Our ref: DOC21/738619-9

MP08_0129 Mod 5 – Orica Kooragang – Prill Tower Scrubber (pollution controls)

The Environment Protection Authority (EPA) has reviewed the submission to the Department of Planning, Industry and Environment (DPIE) by Orica Australia Pty Ltd (Orica) to modify development consent MP08_0129 to upgrade pollution controls for the Prill Tower (the Project) at 15 Greenleaf Road, Kooragang (the Premises). This proposal is known as Modification 5.

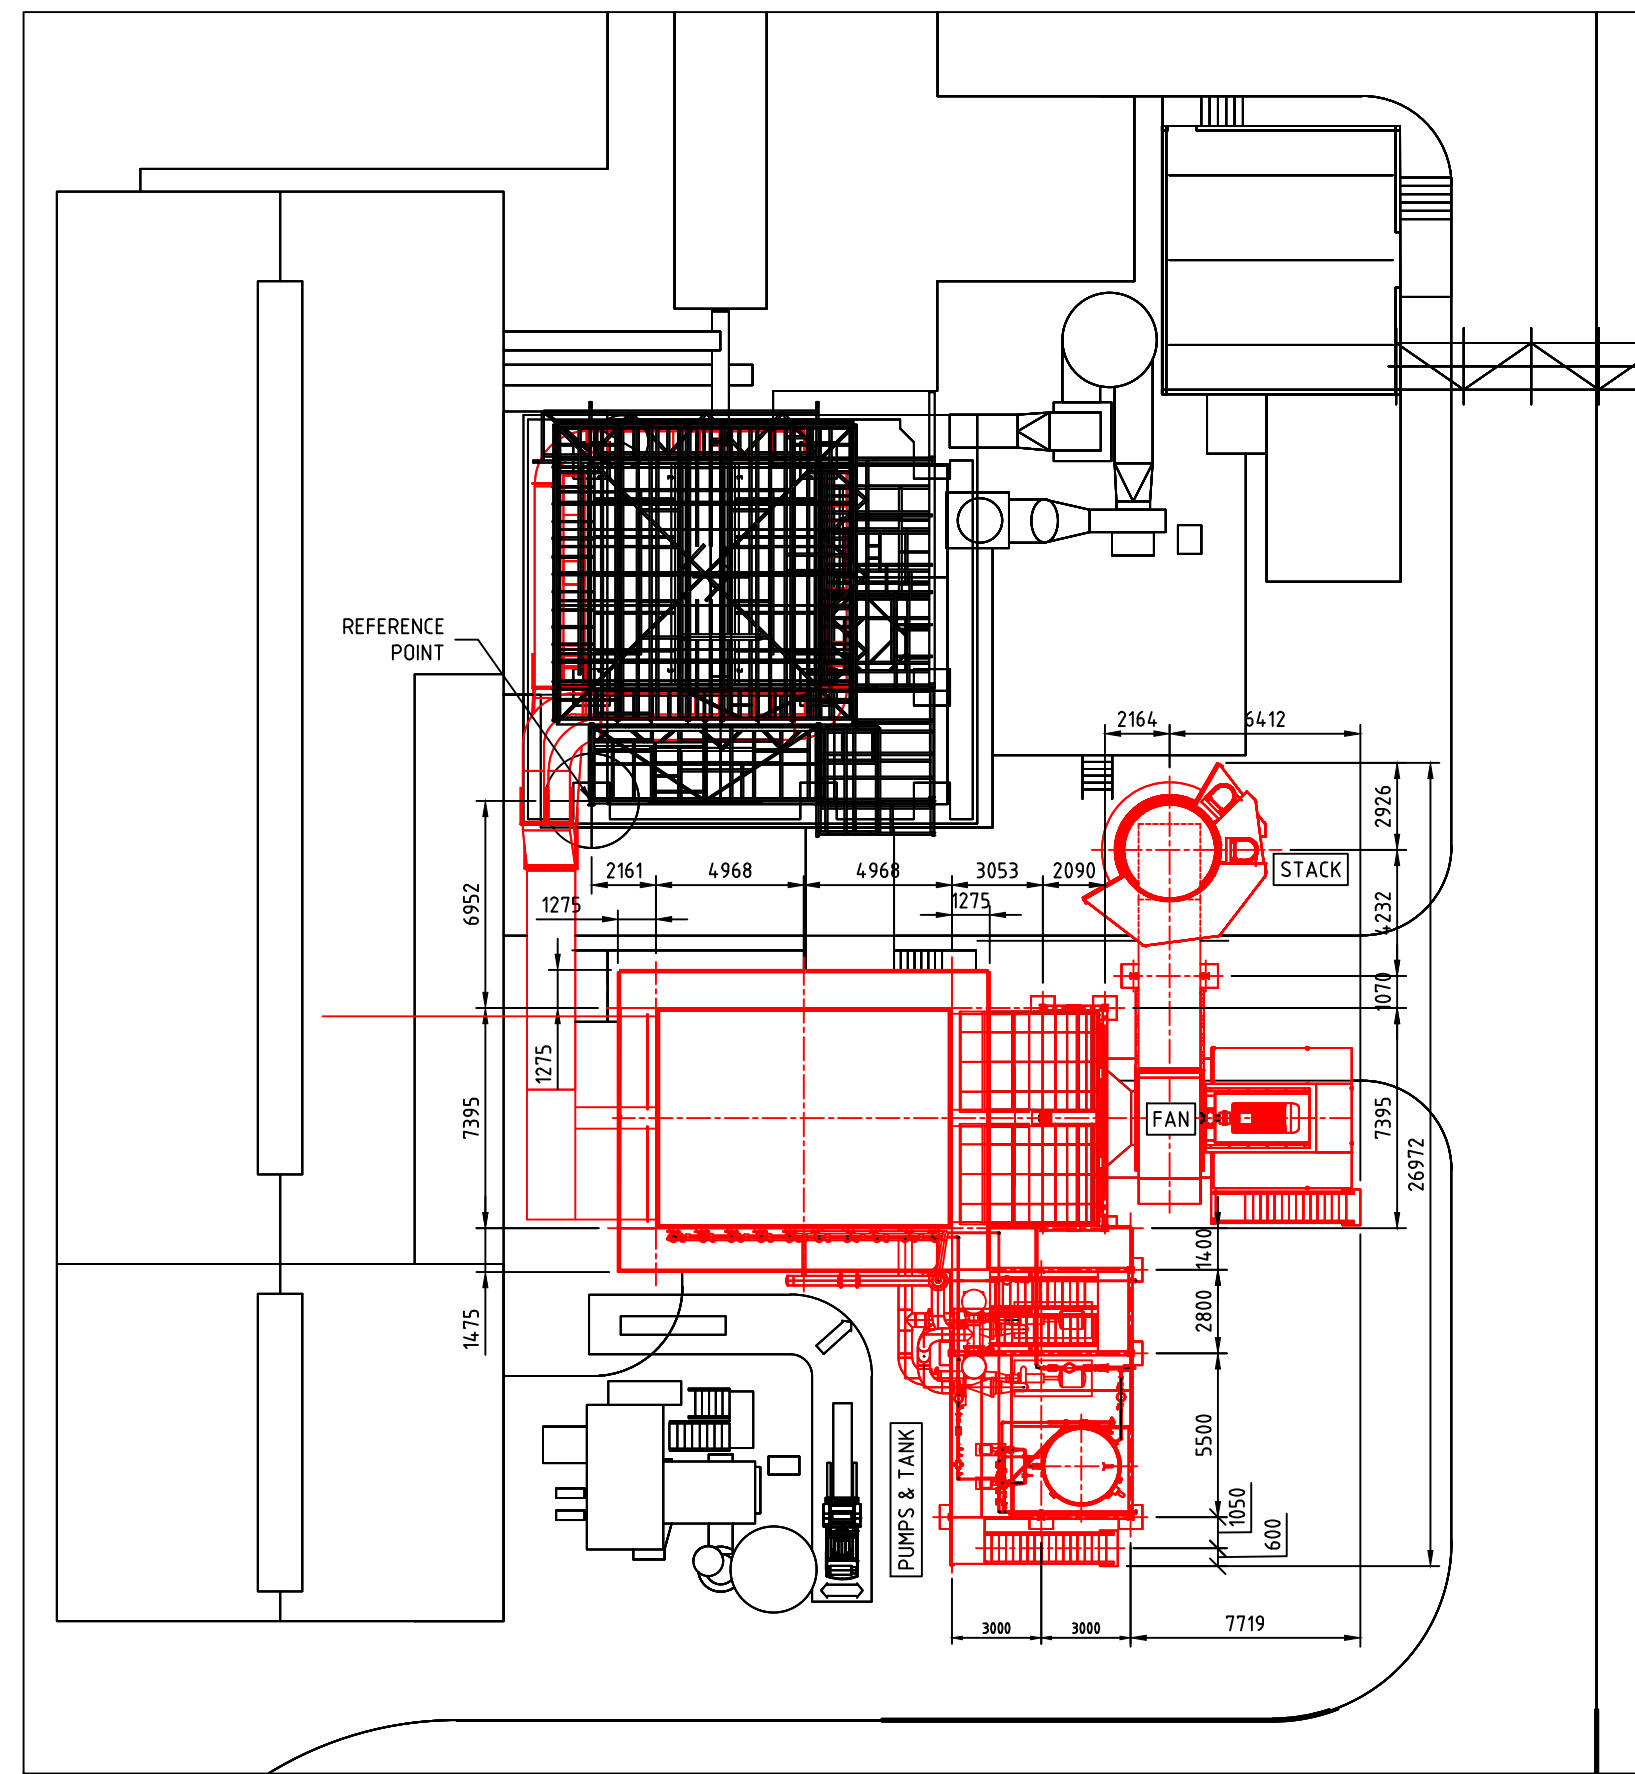
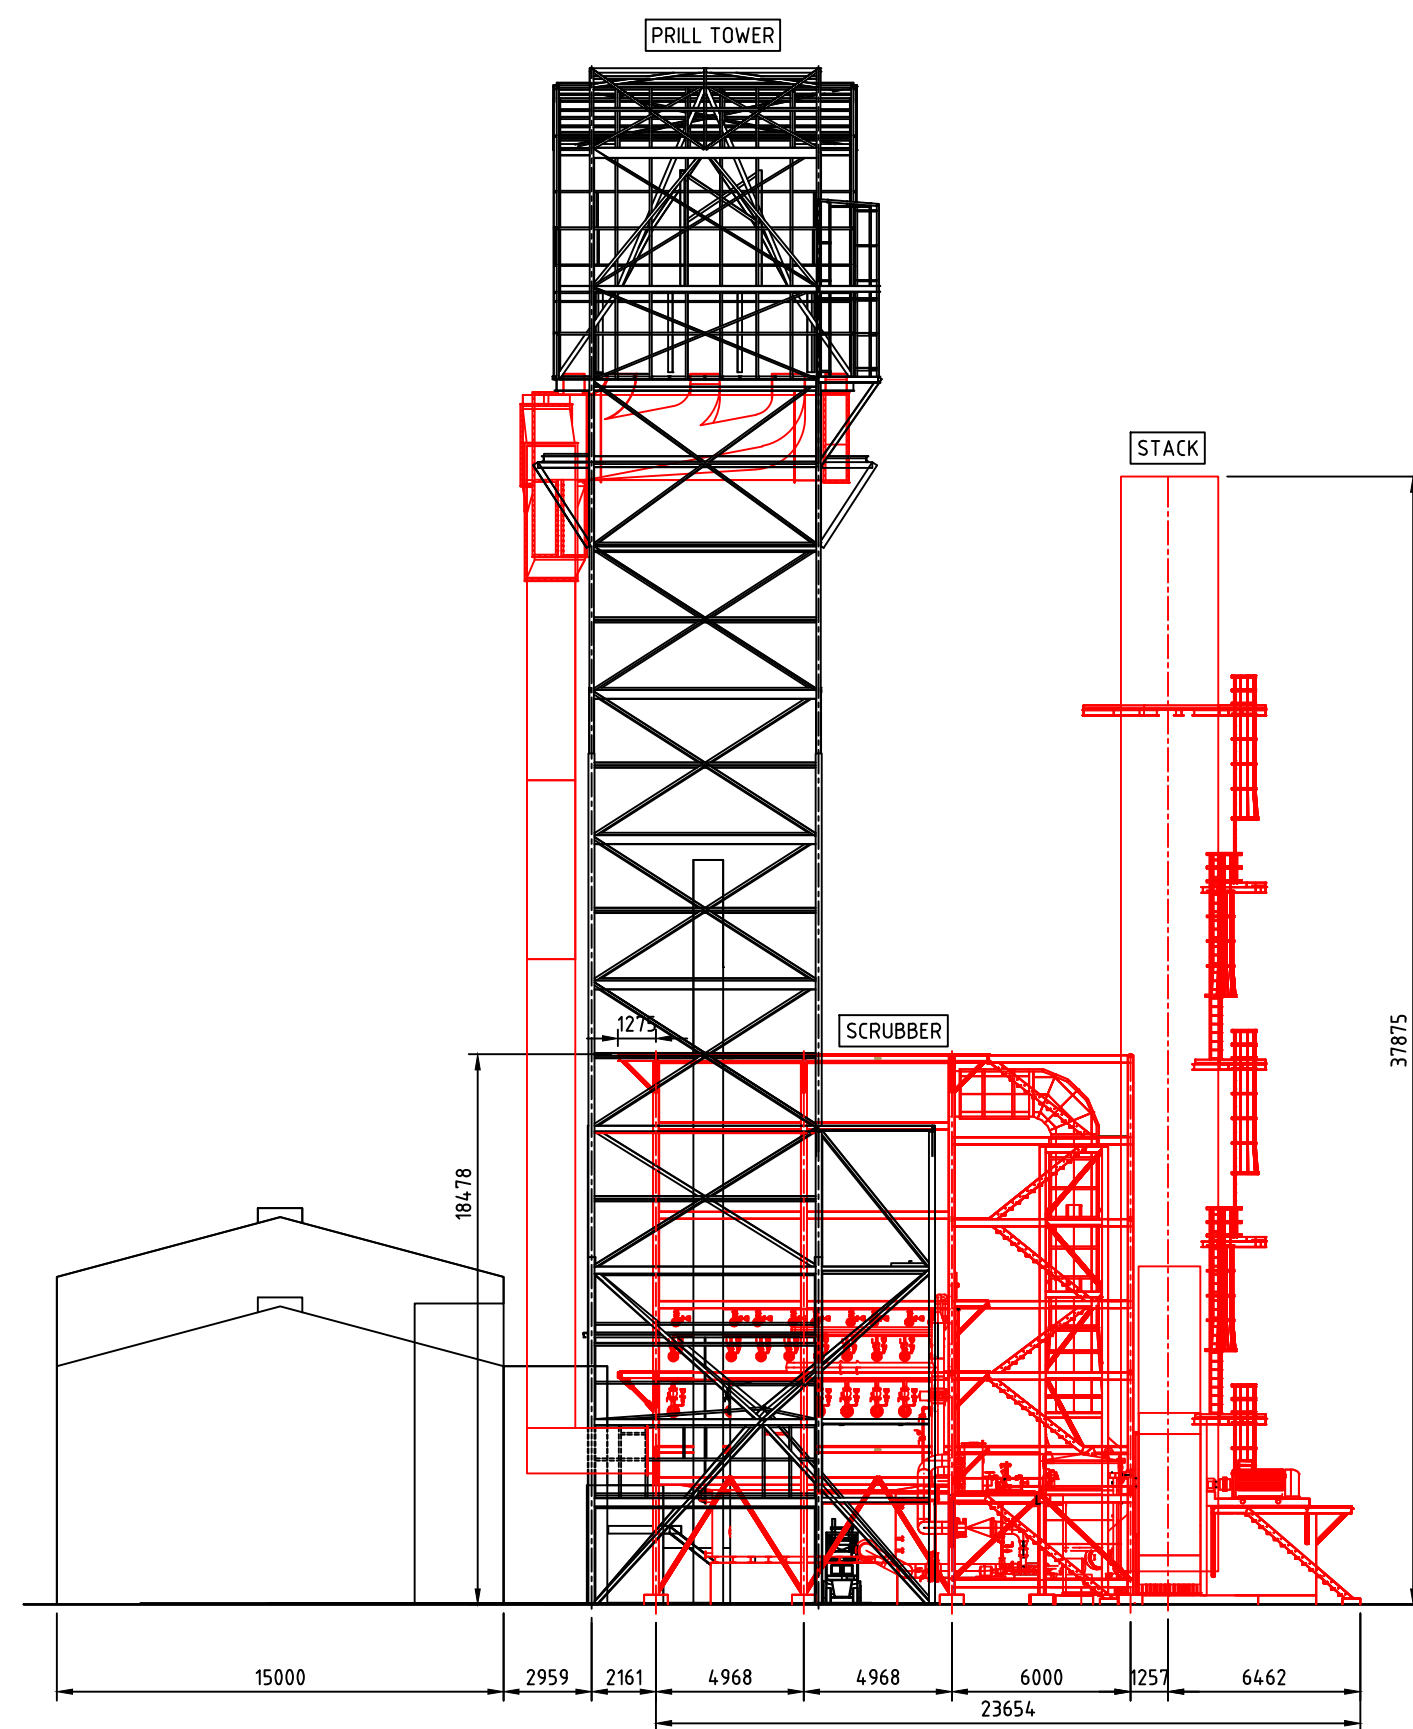
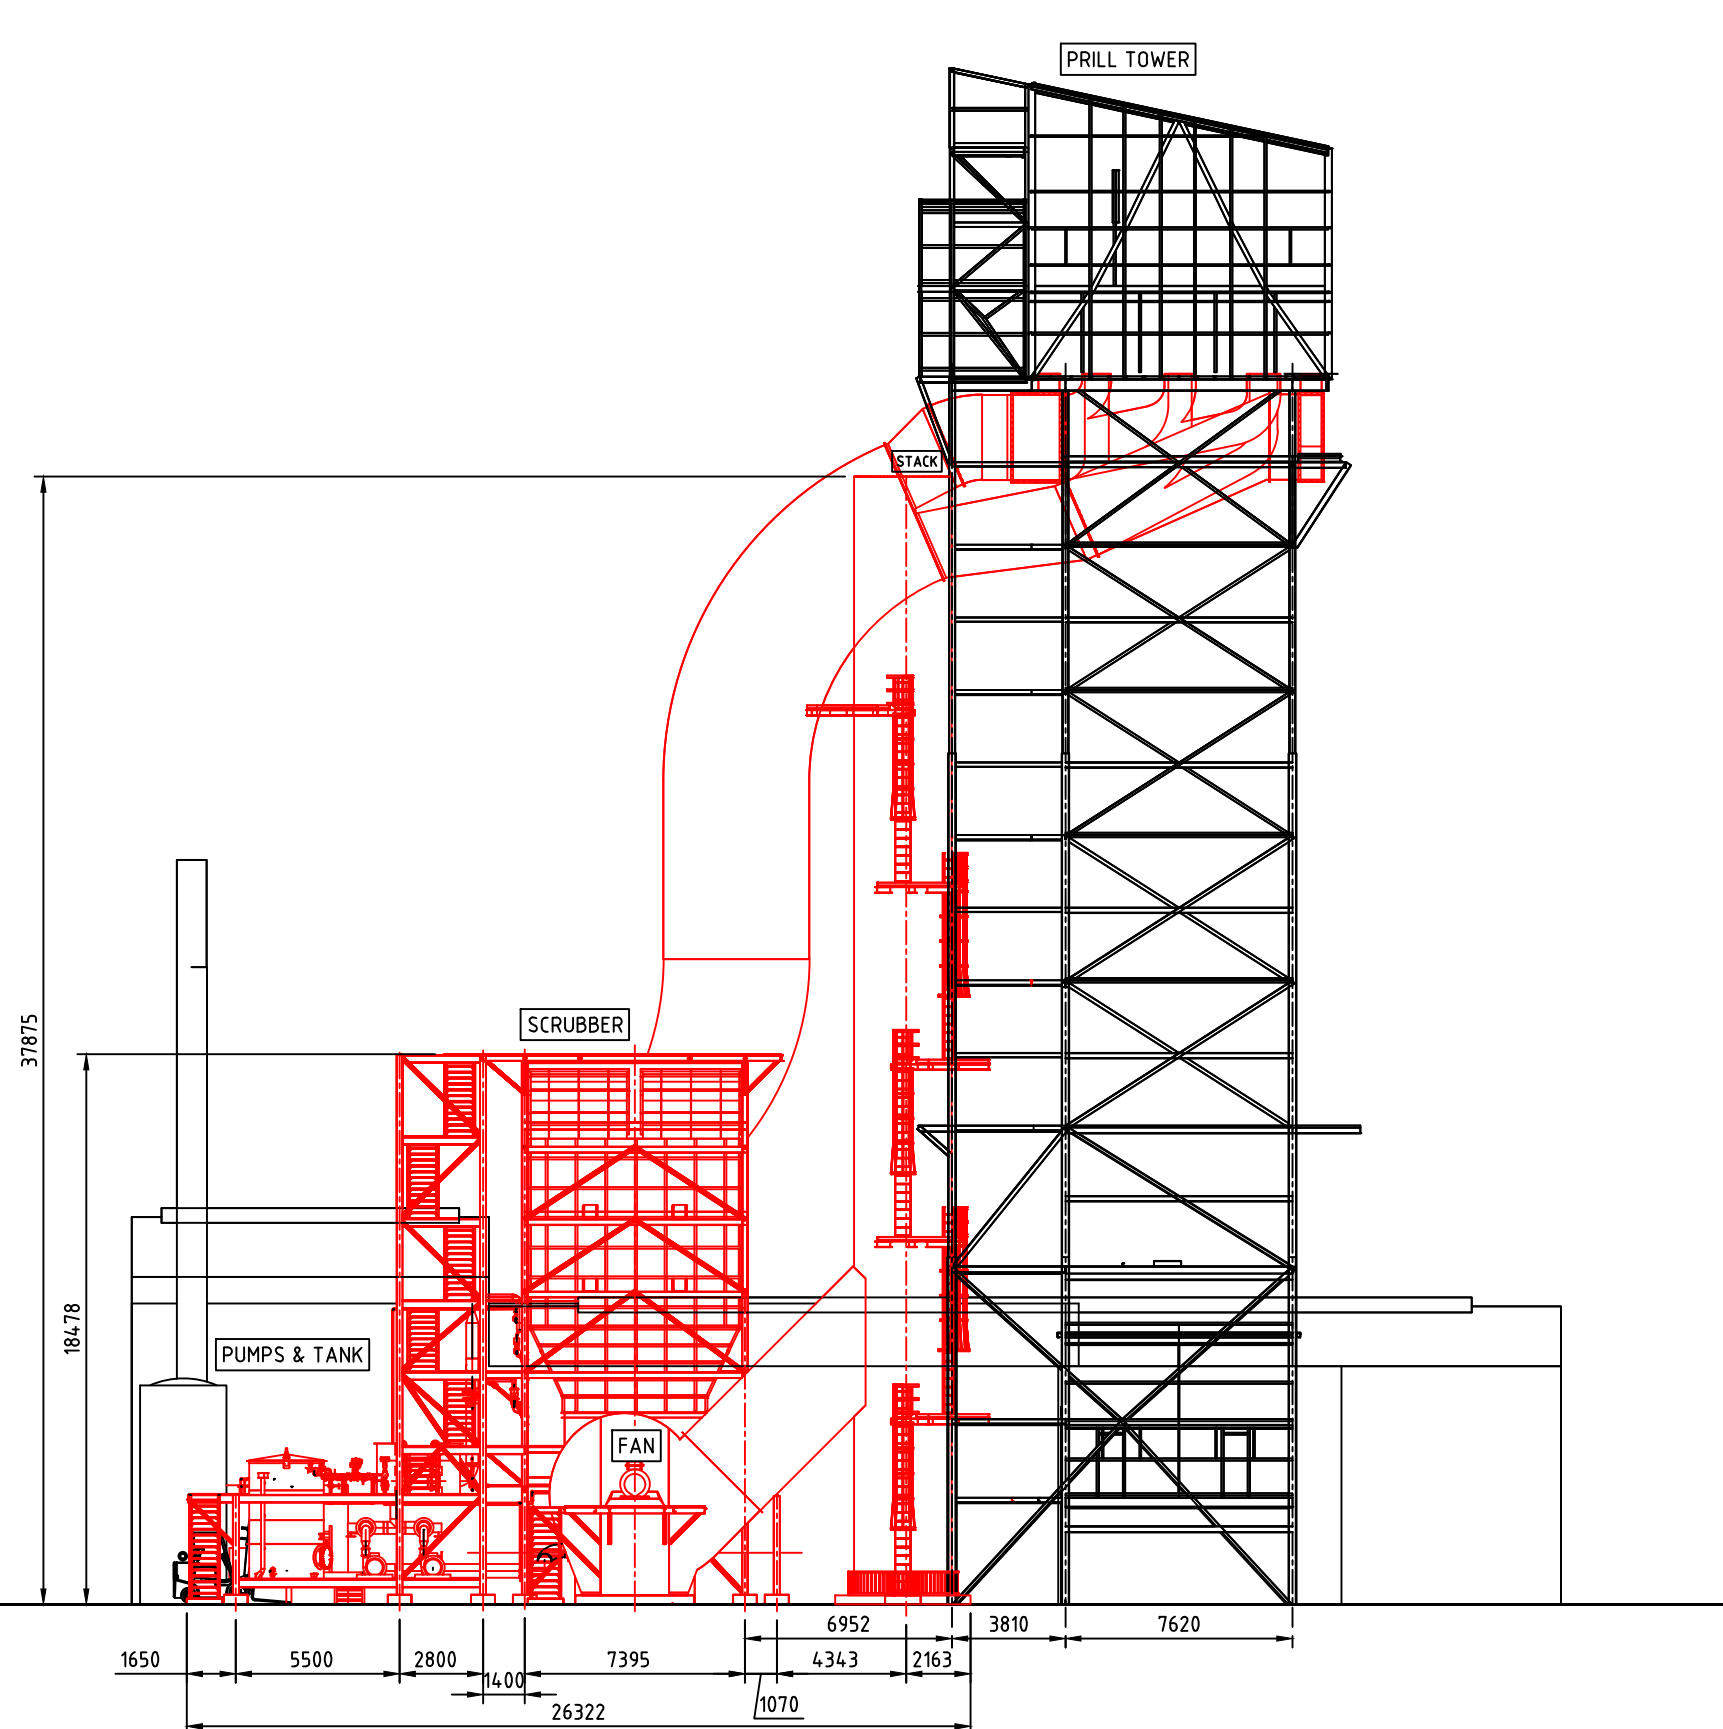
1. The height of the Prill Tower scrubber stack must be 37.9 m from ground level, at a minimum, unless otherwise approved in writing by the EPA.
2. The proponent must undertake a post commissioning air quality verification assessment to be submitted to the EPA.

- A. The height of the Prill Tower scrubber stack must be 37.9 m from ground level, at a minimum, unless otherwise approved in writing by the EPA.
- B. Amend Condition P1.2 –
 - a. Delete Discharge Point 16 being the current air discharge point for the Prill Tower
 - b. Add Discharge Point 40 being the outlet of the Prill Tower scrubber stack.
 (Note this means direct discharge from the Prill Tower will not be permitted post commissioning of the Project.)
- C. Amend Condition L3.4 for Discharge Point 40 as below:
